March 16, 2006

HTE#04-5-10353R

Your application for a four bedroom home on lot 46 in Plantation at Vineyard Green has been reviewed and denied. The lot is currently permitted for a three bedroom house. This letter is at your request to inform you of your options.

SITE PLAN APPROVAL

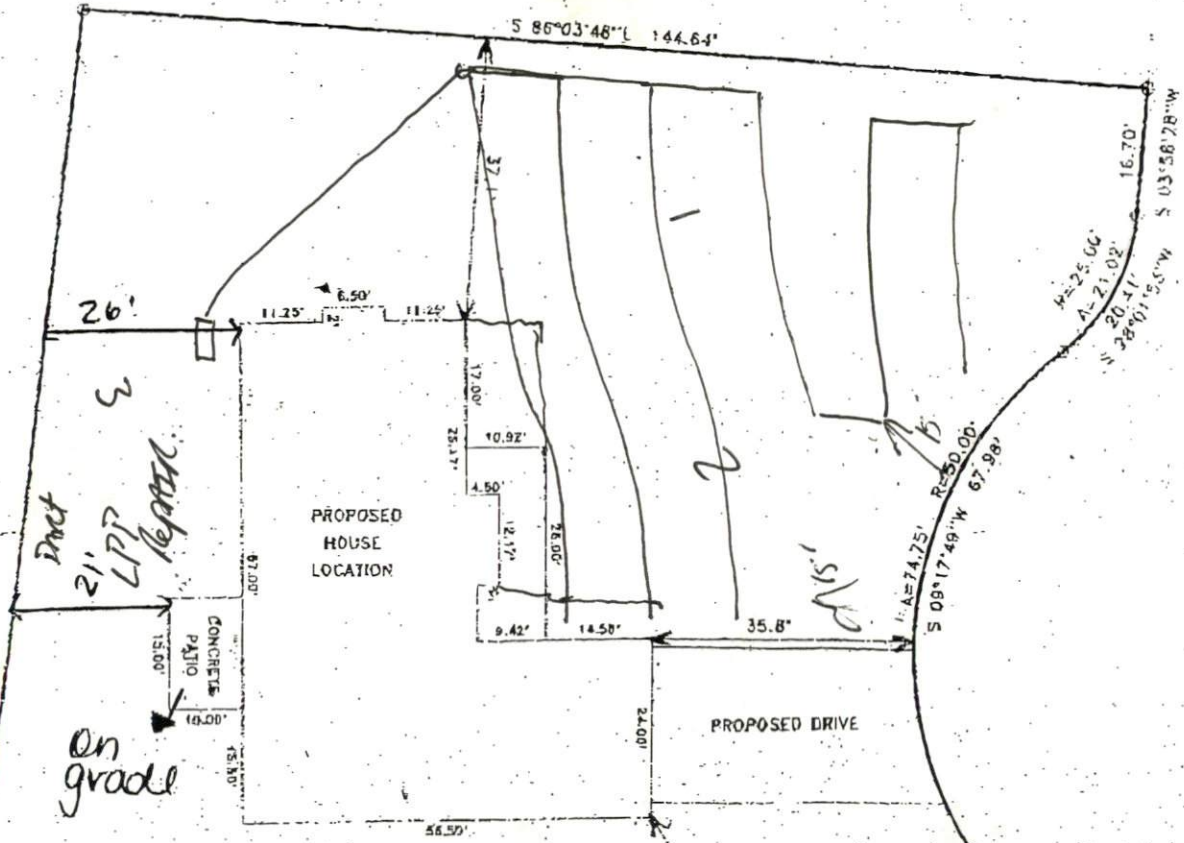
The application has been denied based on available space on this lot. A pretreatment system may be a suitable alternative. In order for this to be determined a Soil Consultant must run the appropriate tests to determine if the soil is suitable for such a system and if there is enough room. You may also build a three bedroom house with your current permit. Please contact me if you have any further questions.
